City of Portland, Maine - Building or Use Permit Application

Permit No:	04-1362	Issue Date:	NOV 24 2004	CBL:	317 B005001
------------	---------	-------------	-------------	------	-------------

Location of Construction:	375 Riverside St	Owner Name:	Reynolds Marianne M
Business Name:		Contractor Name:	Patco Construction
Lessee/Buyer's Name		Phone:

Proposed Project Description:	New 3010 Sq Ft Show Room
-------------------------------	--------------------------

TYP. PAVED PARKING LOT SECTION
 NOT TO SCALE

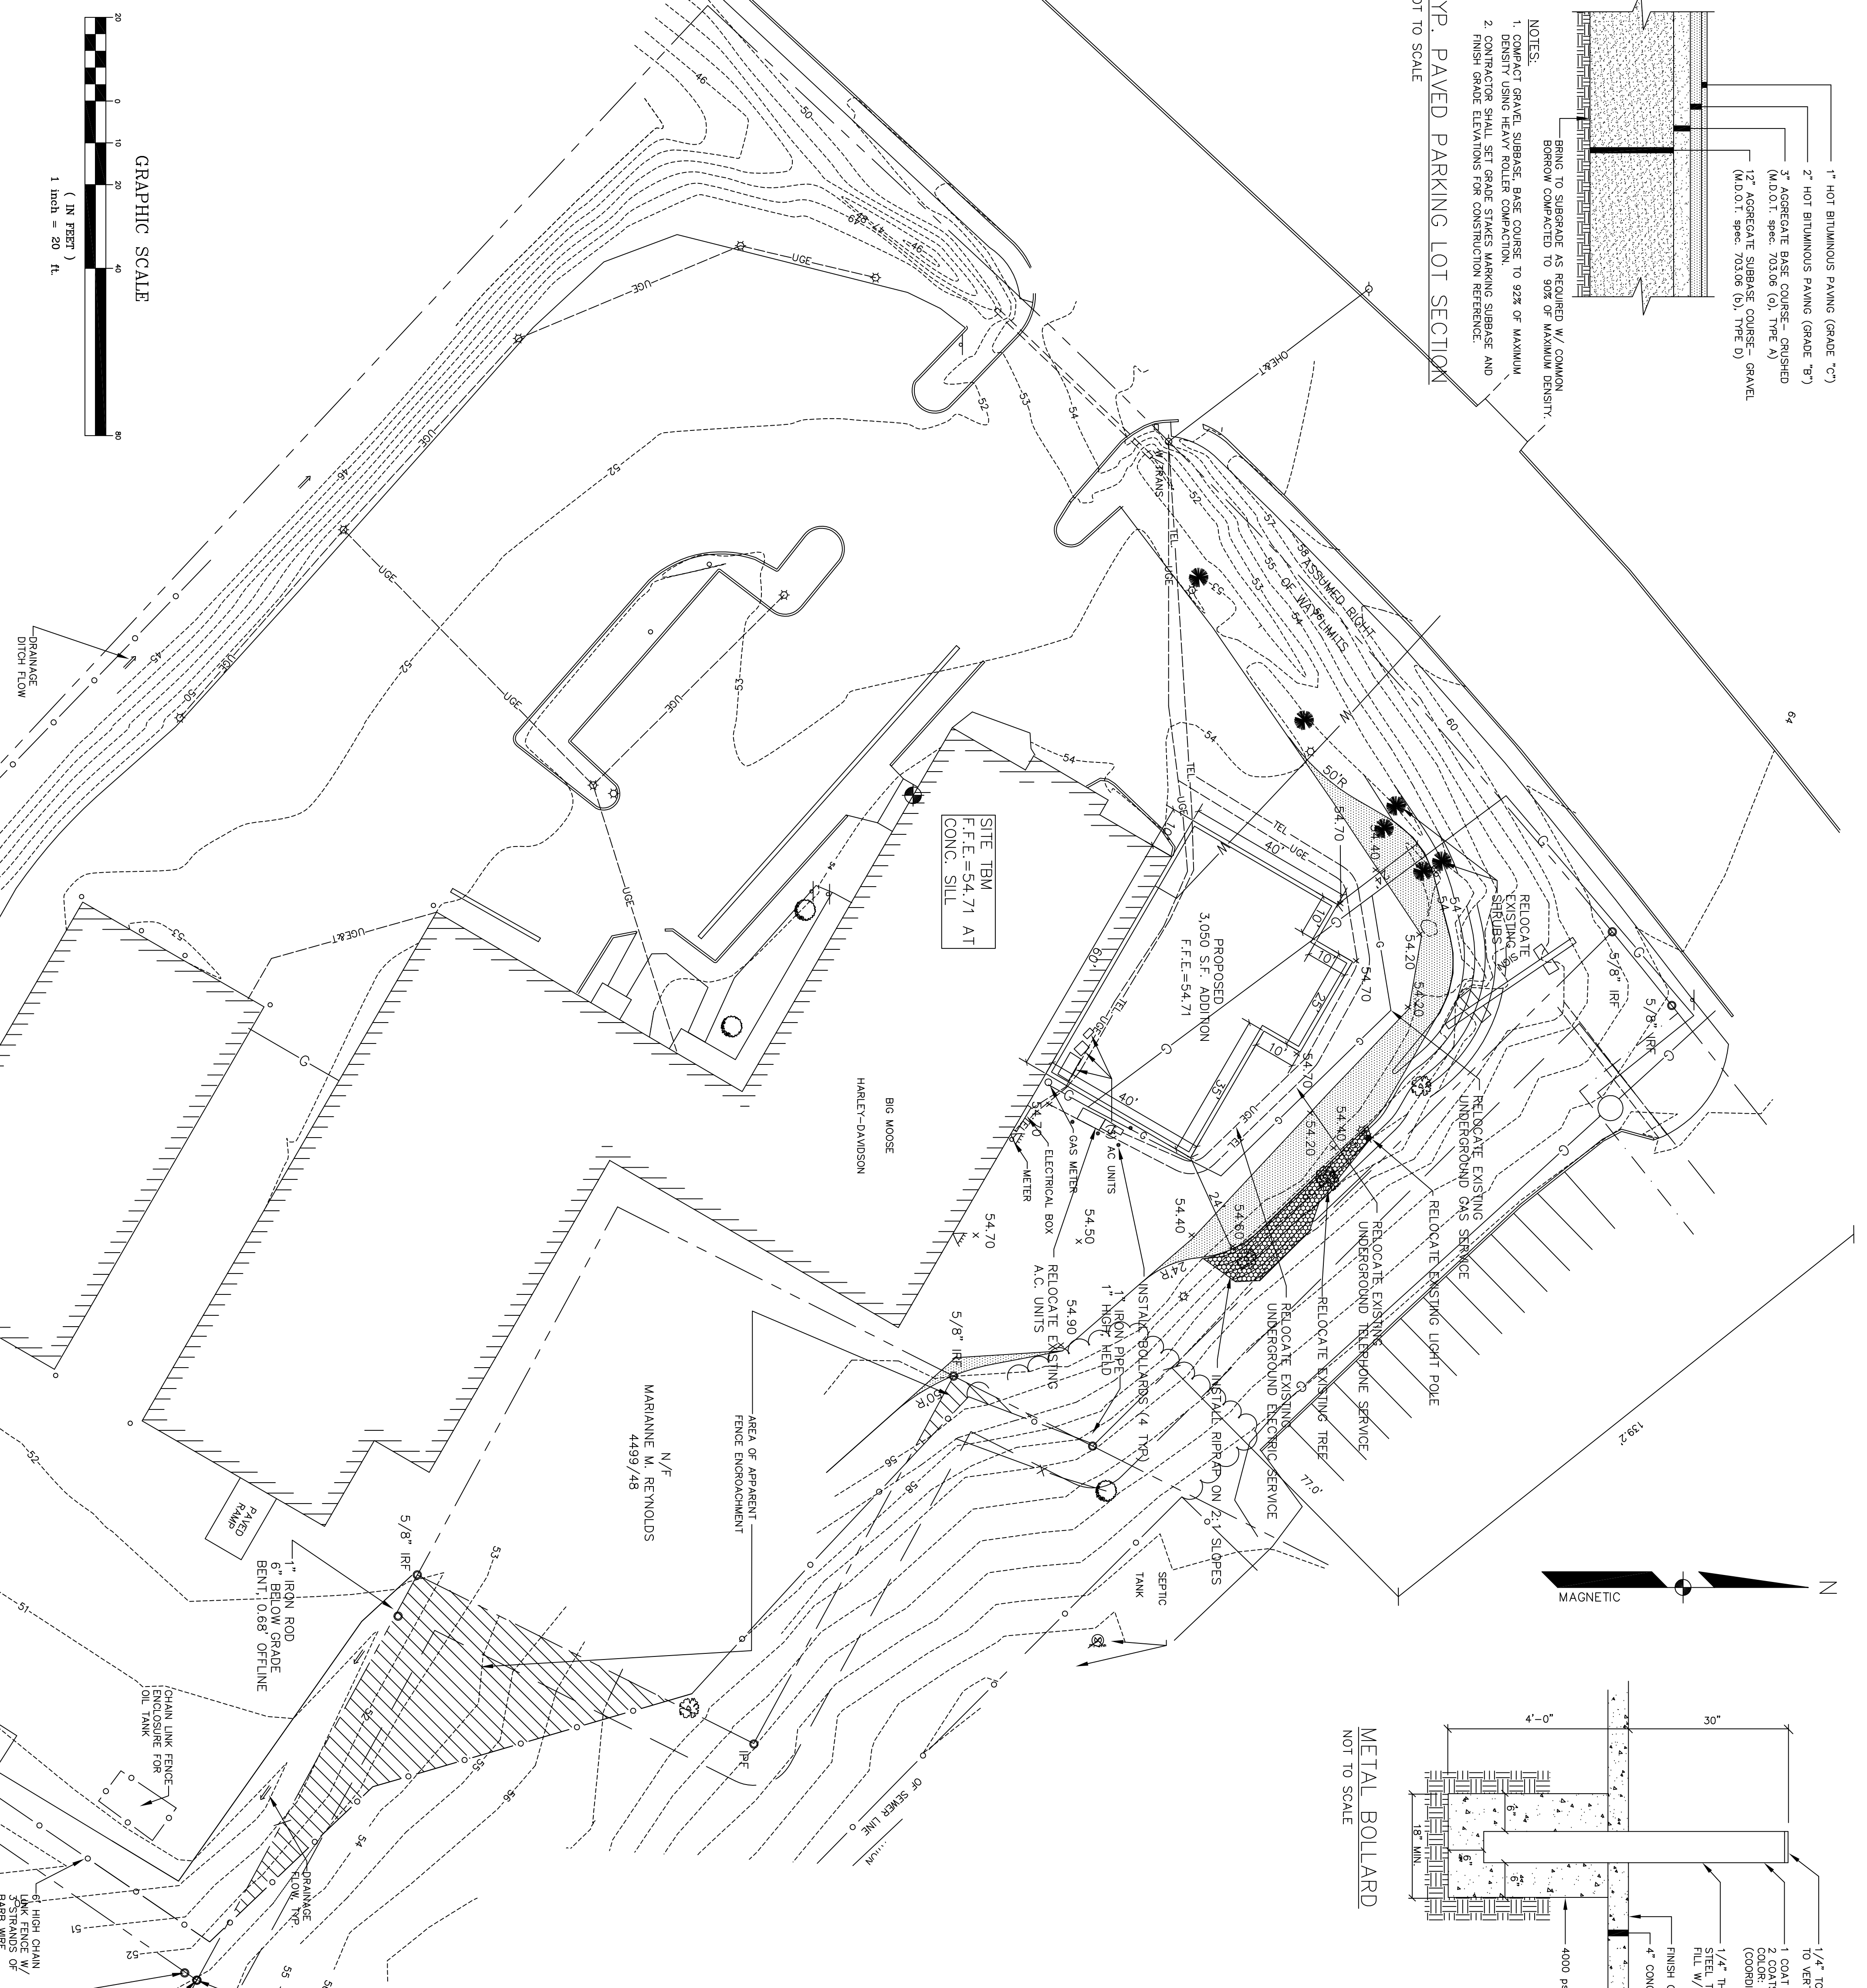
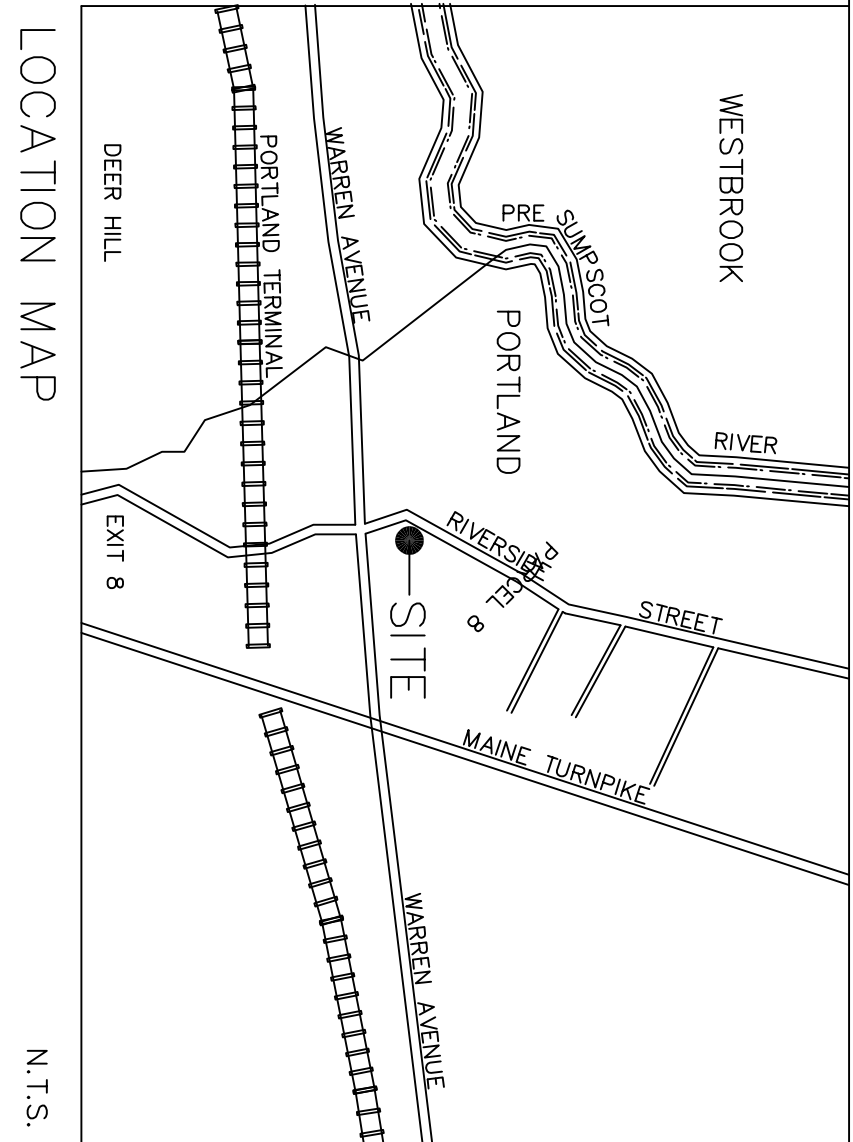
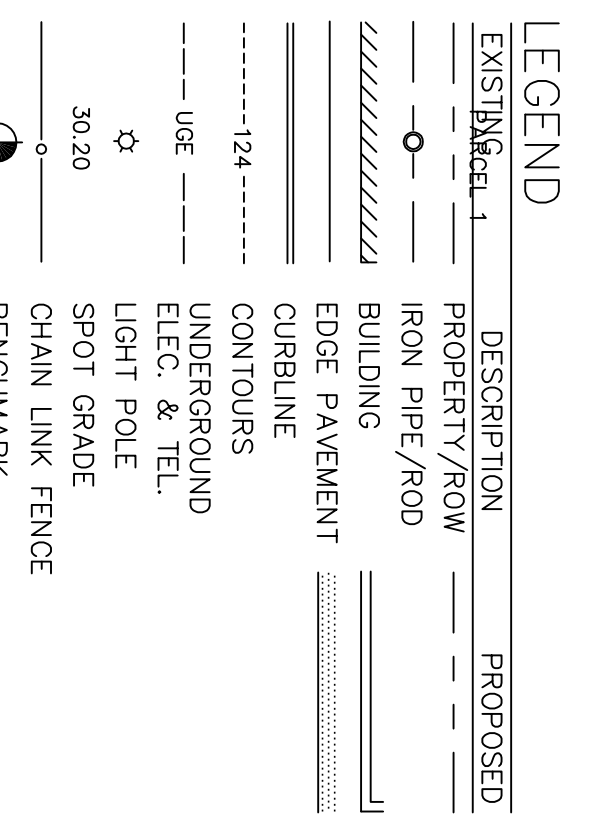
- 1) vii. The applicant shall contribute \$1,500 to the City for the improvement of a drainage channel and outfall crossing downstream of Handyman Rental, on Riverside Street.
- 2) vi. Bollards shall be installed around the relocated AC units, gas entry valve and other related equipment.
- 3) v. The applicant must be responsible to install and maintain erosion control measures in accordance with the submitted narrative and the Best Management Practices.

- 4) iv. At least 15" of gravel and 3" of asphalt shall be installed for the paved section.
- 5) iii. If necessary, a grading or other form of easement shall be submitted to staff for the new pavement surface, which will extend slightly onto the adjacent property, just off the northeast building corner.
- 6) ii. A final plan should provide specific spot grading or contours for the paved area behind the rear of the expansion. A drainage inlet may be warranted on the southeast side of the expansion.
- 7) i. Utility capacity letters from Portland Water District and Portland Sewer Division shall be submitted to staff.
